## Application by Drax Power Limited for the Drax Bioenergy with Carbon Capture and Storage Project

### The Examining Authority's written questions and requests for information (ExQ1)

Issued on 24 January 2023

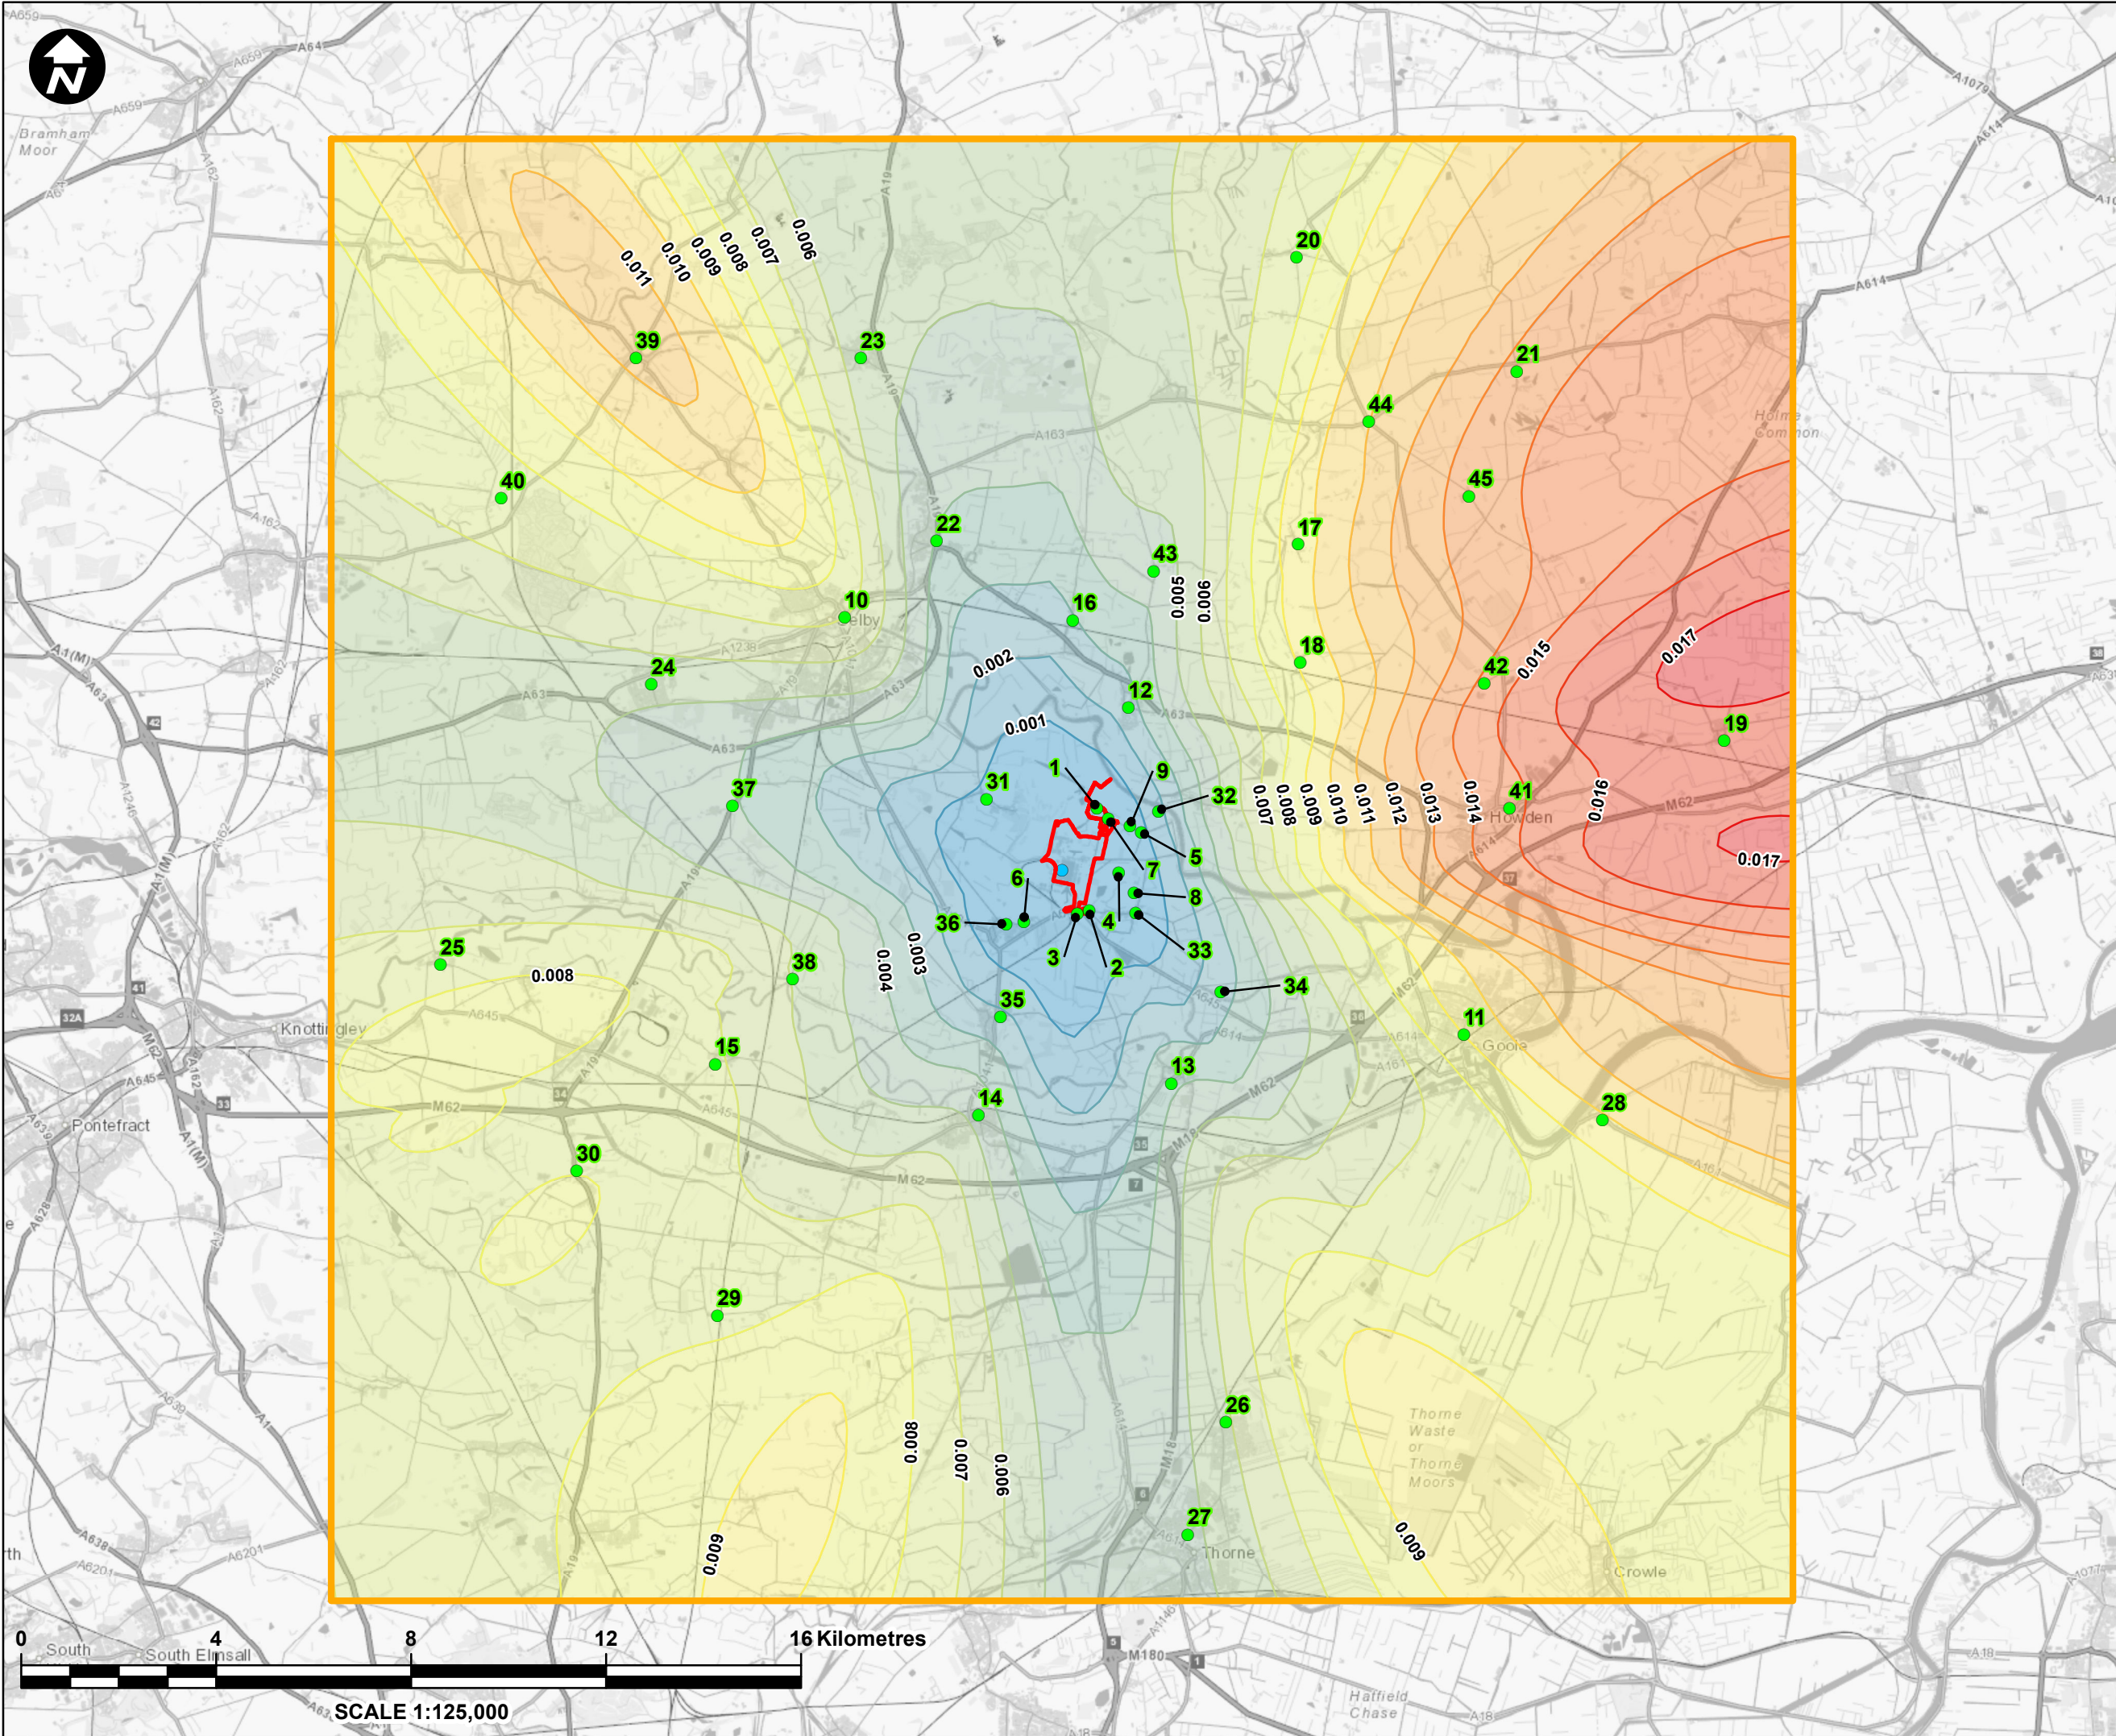
AQ.1.4	EA	<p>Figure 6.8 [APP-075] shows a significant area that would fall into the category of slight adverse impact (<math>\geq 6\%</math> of EAL) for annual nitrosamines process contribution, and the dispersion pattern suggests that the area would extend beyond the study area.</p> <p>Does the EA consider the study area to be sufficient for the assessment of the impact of nitrosamines?</p>
AQ.1.5	EA	<p>Is the EA satisfied that any potential uncertainties in the modelling of atmospheric degradation of amines has been addressed by the Applicant?</p>
AQ.1.6	Applicant	<p>Can the Applicant provide an explanation as to why, in reference to paragraph 6.5.47 of the ES [APP-042], the assessment of cumulative impacts is dealt with differently in relation to ecological vs. human receptors?</p>
AQ.1.7	EA/ SDC	<p>Can the EA and SDC confirm that they are satisfied with the Applicant's approach of undertaking no additional project-specific air quality surveys as per paragraph 6.5.49 of the ES [APP-042]?</p>
